SUBMISSION RE APPLICATION 07\_0103 APEX ENERGY  
EXPLORATION PROJECT

In my comments on the Application, page numbers mentioned are those in the Environmental Assessment Report by Olsen Consulting dated March 2009.

Figure 3.1B – Aerial Photographs of Borehole Locations in Context of Surrounding Environments

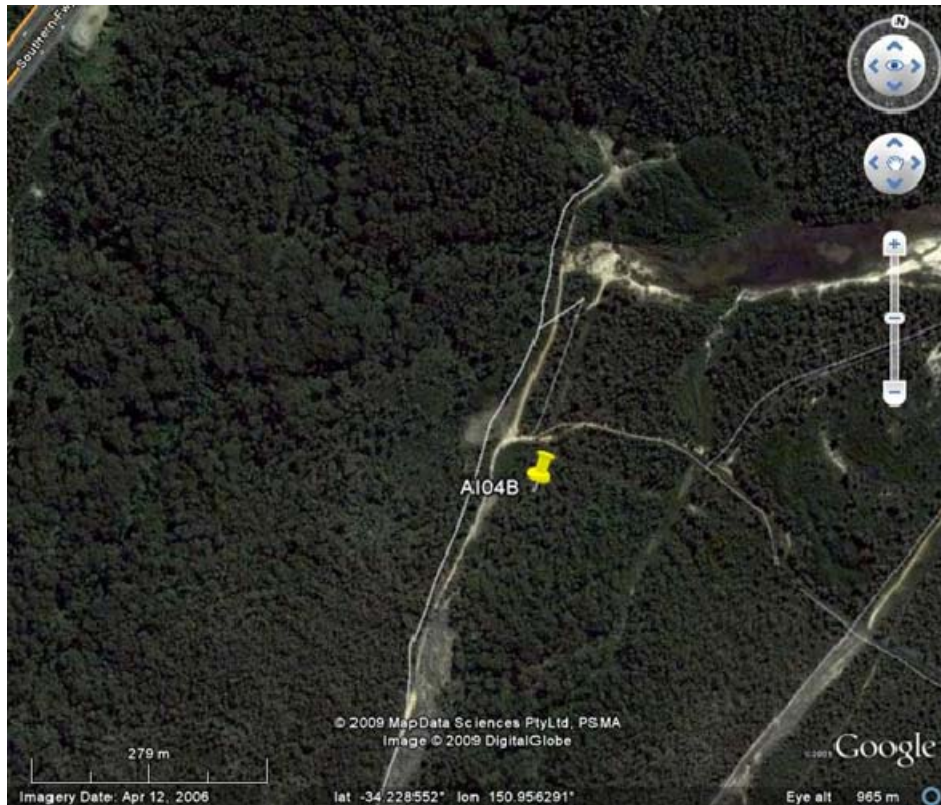
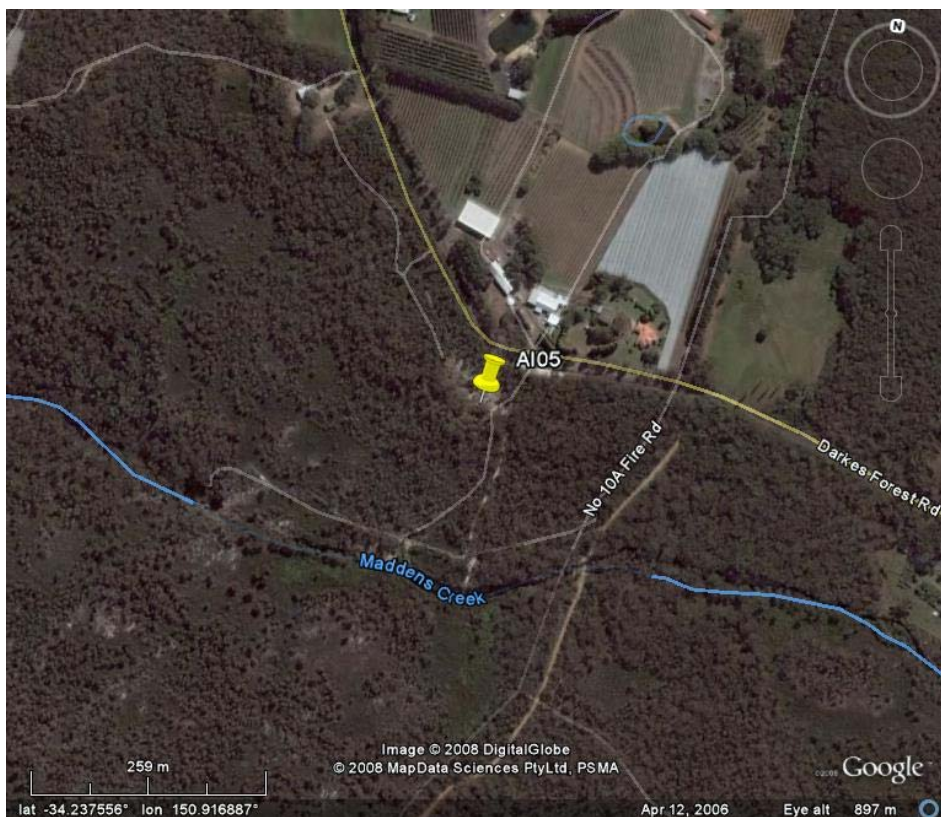
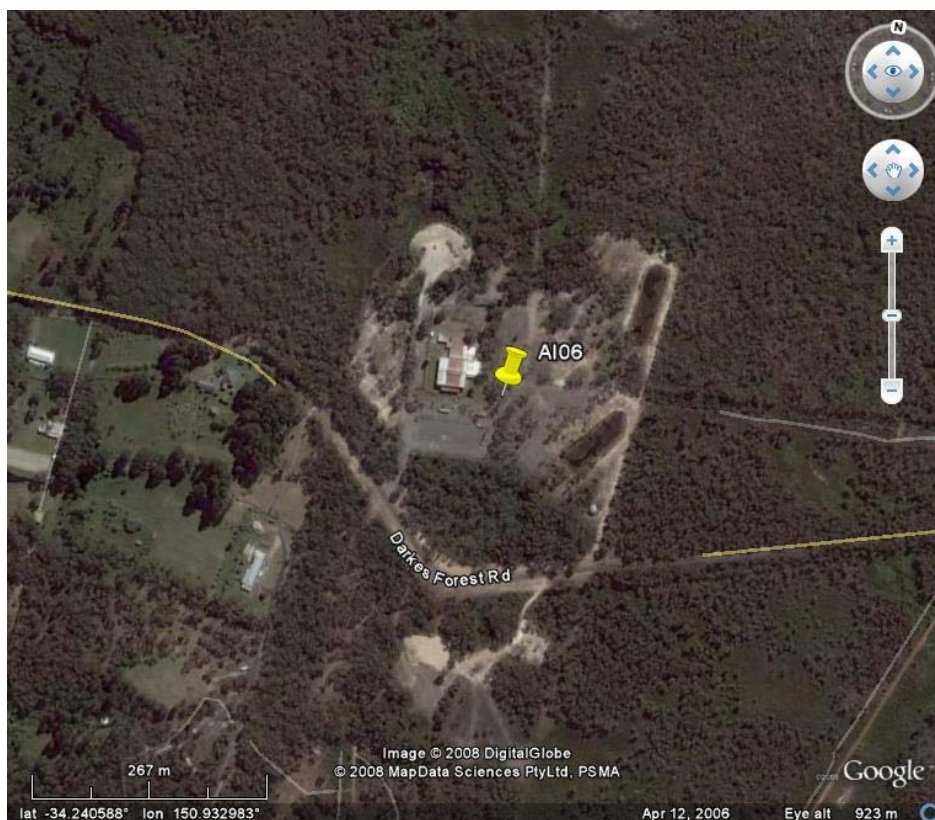
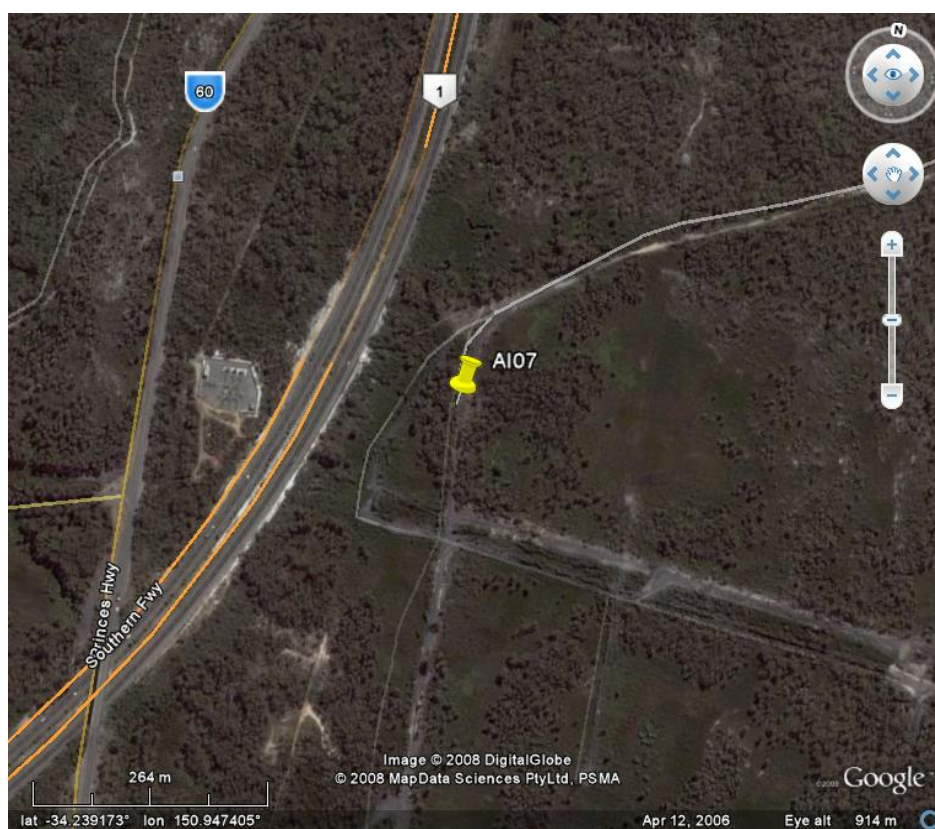
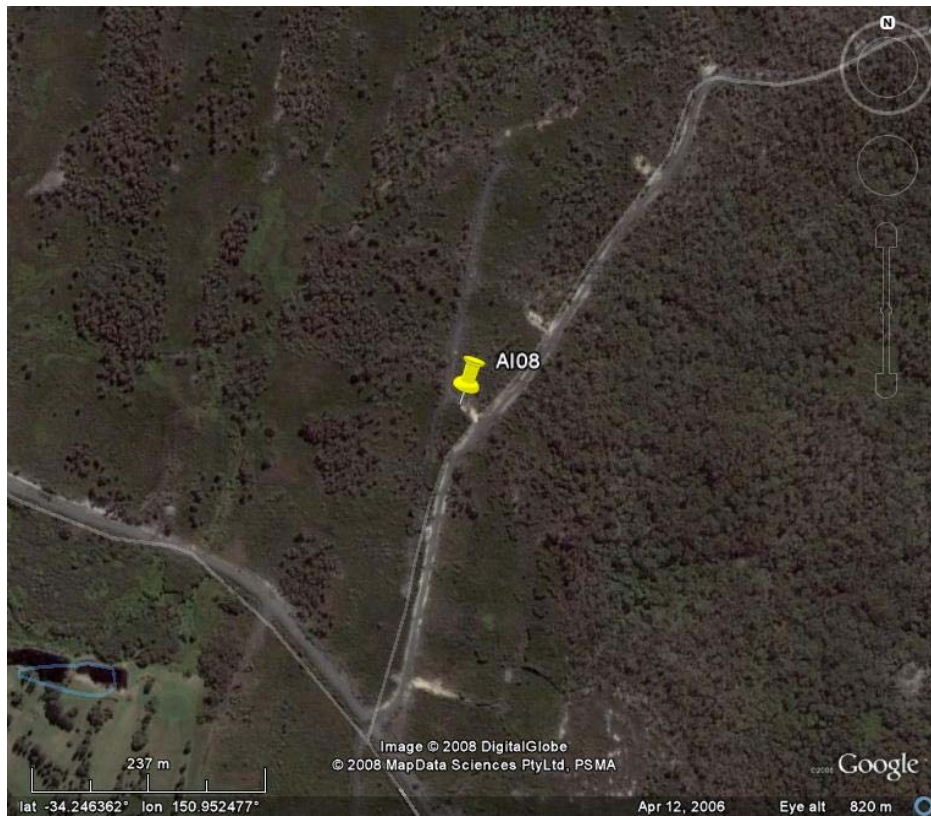
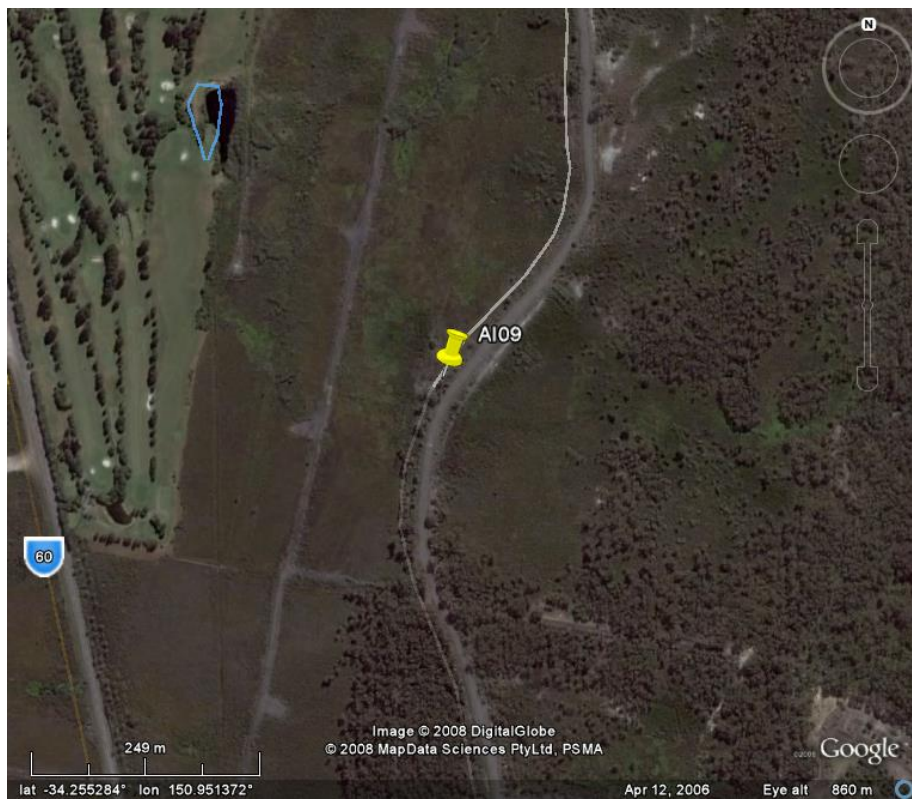
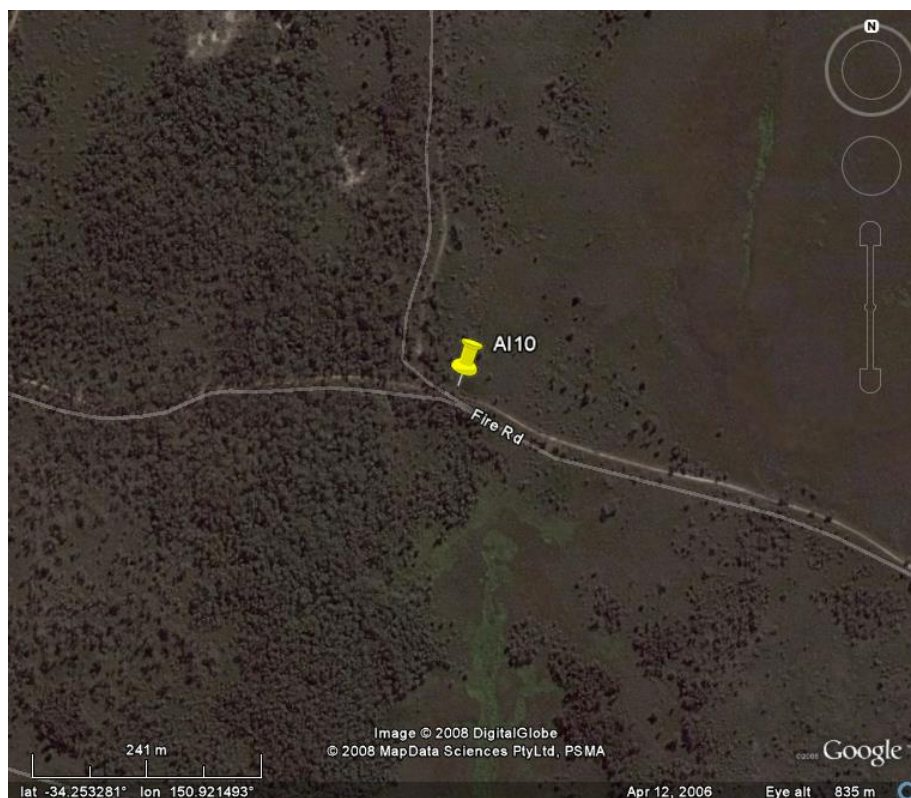
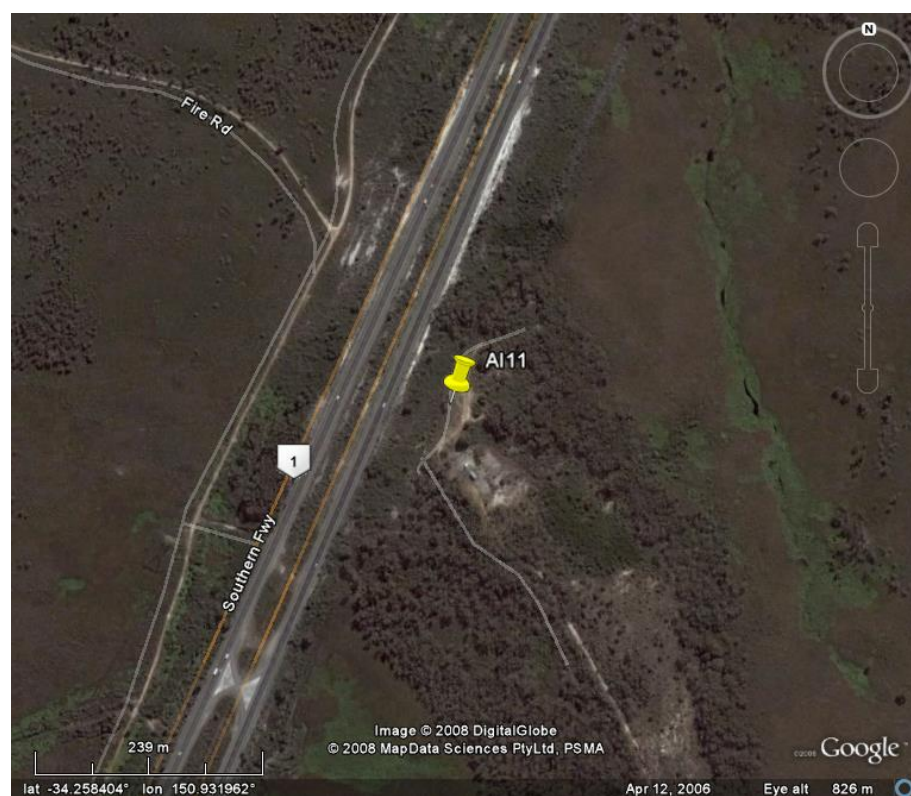
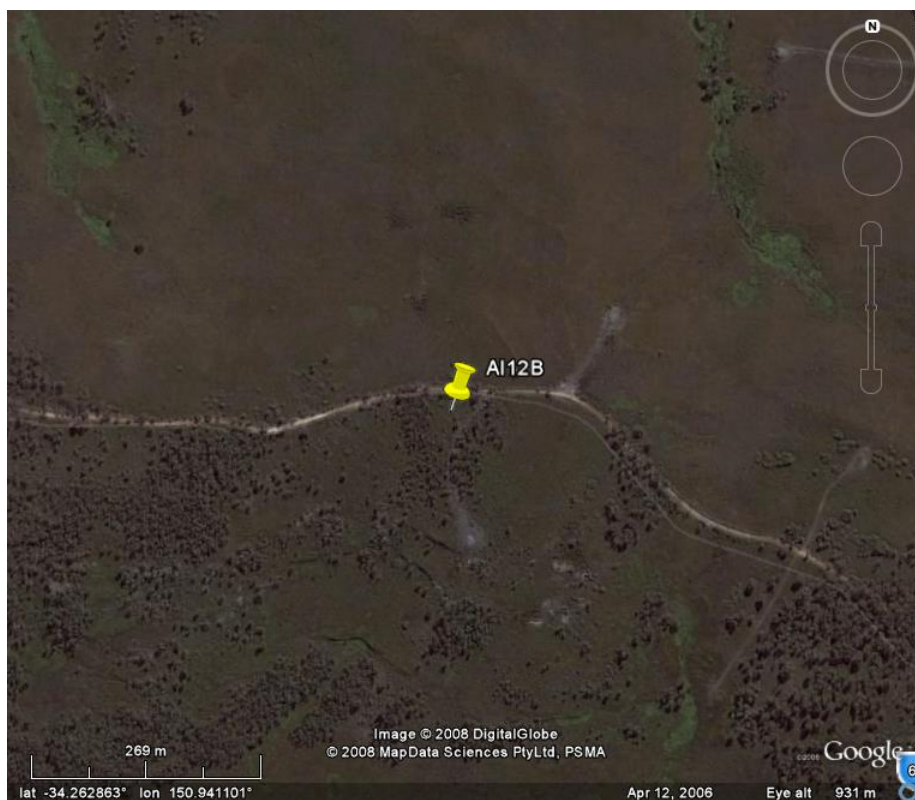
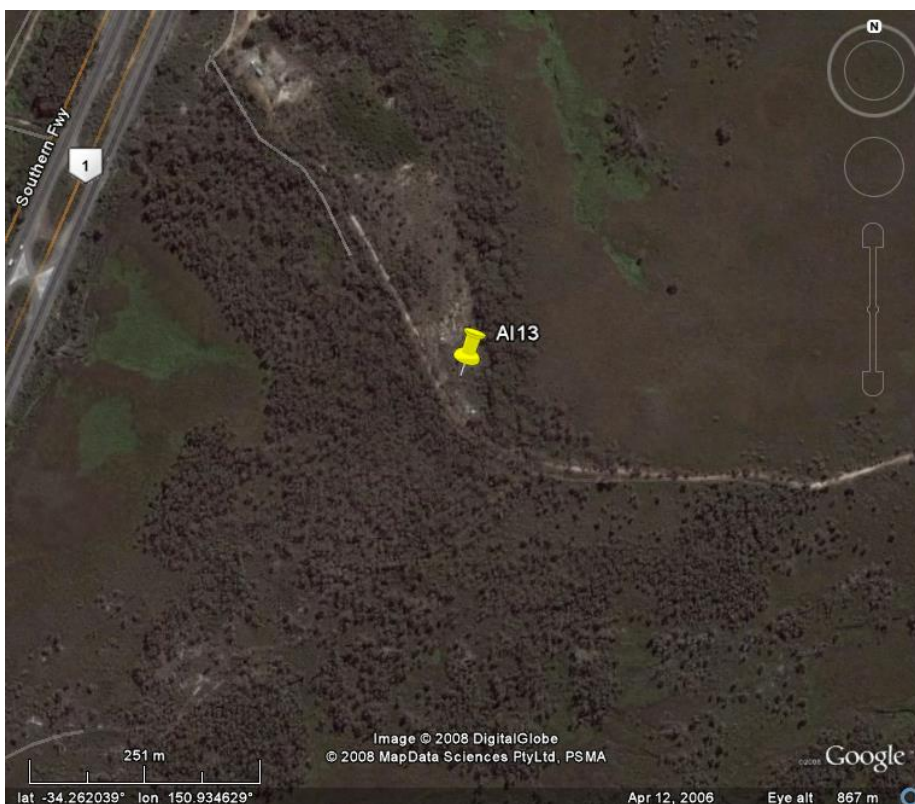
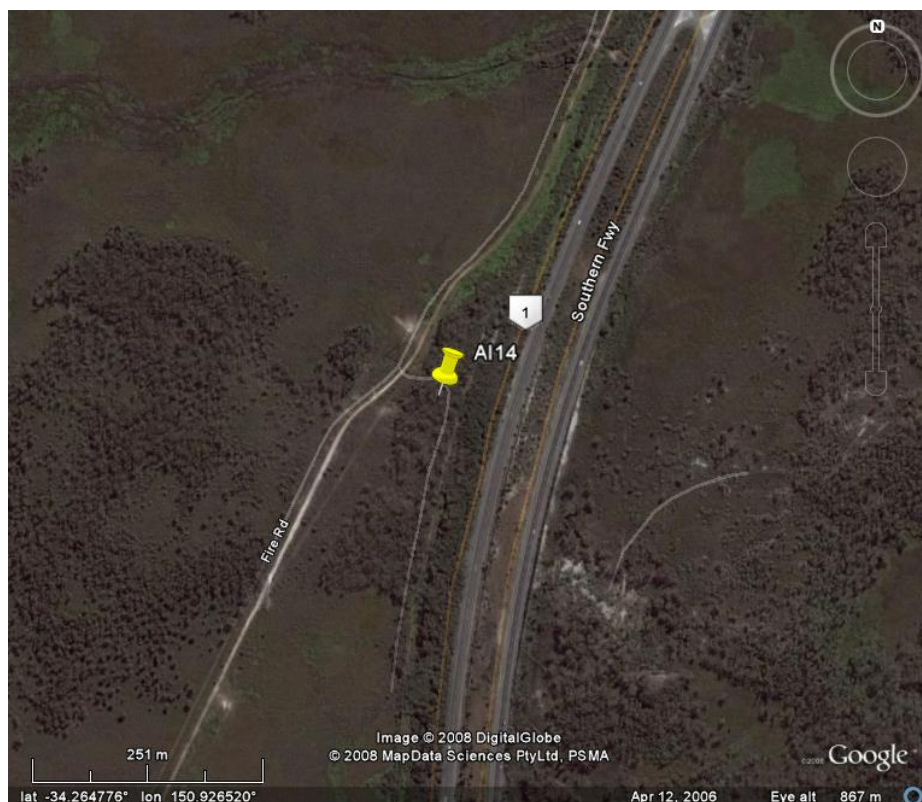
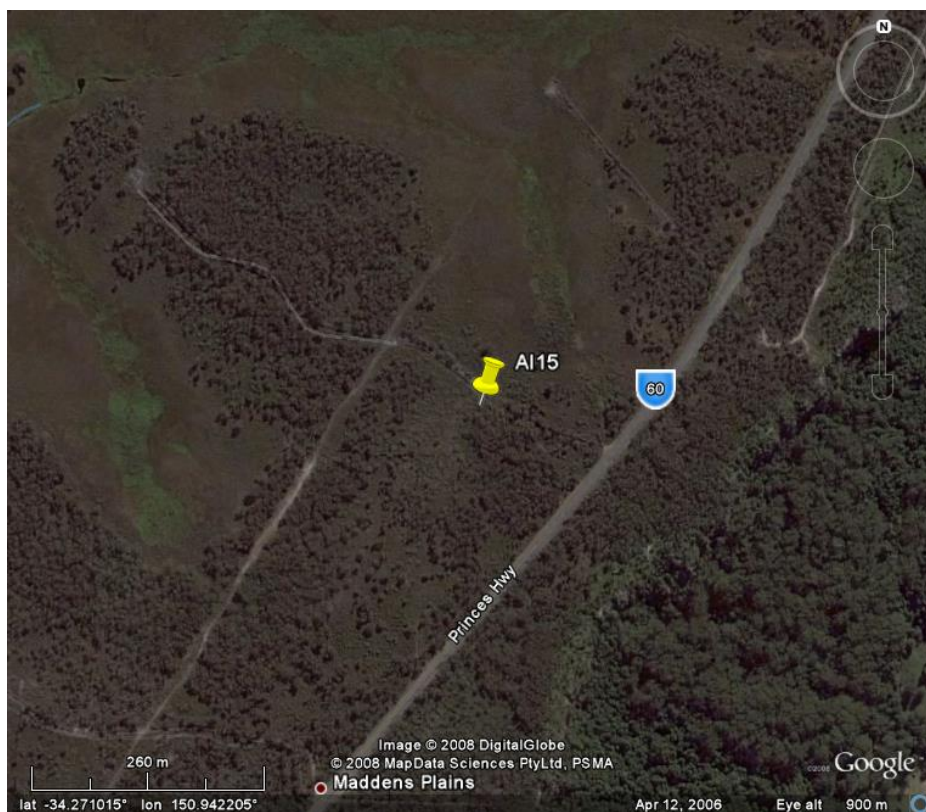
p 2. Although the drill sites are mainly near or on existing tracks, and the total area to be cleared is not large, this does not mean that environmental impacts are negligible. As the Google images on pp 20-26 show clearly, only A114, A116 and A118 are on wooded ridges. All other sites are beside upland swamps, and a 50-60m radius of disturbance as indicated on p31 would encroach into the swamps. This means that there would be a significant increase in the existing disturbance, and the additional impacts of compaction and channelled runoff across the surface. Also, while many of the sites lie beside existing fire trails, these trails are not heavy duty access roads. To give the drill rigs and other large vehicles access along them is likely to cause significant widening and disturbance, especially for the work-over rigs (p40). This project will NOT simply operate without any noticeable change in the local environment. Similarly, the comment that these corridors would be used for subsurface reticulation of any developed wells (p9) glosses over the impacts of the traffic needed to dig trenches, lay pipes etc. And as is shown by Figure 3.5 (p32) and the details of sumps etc on p 56, there will be drains, bunds and levelled areas constructed, not just a small area 'cleared'.
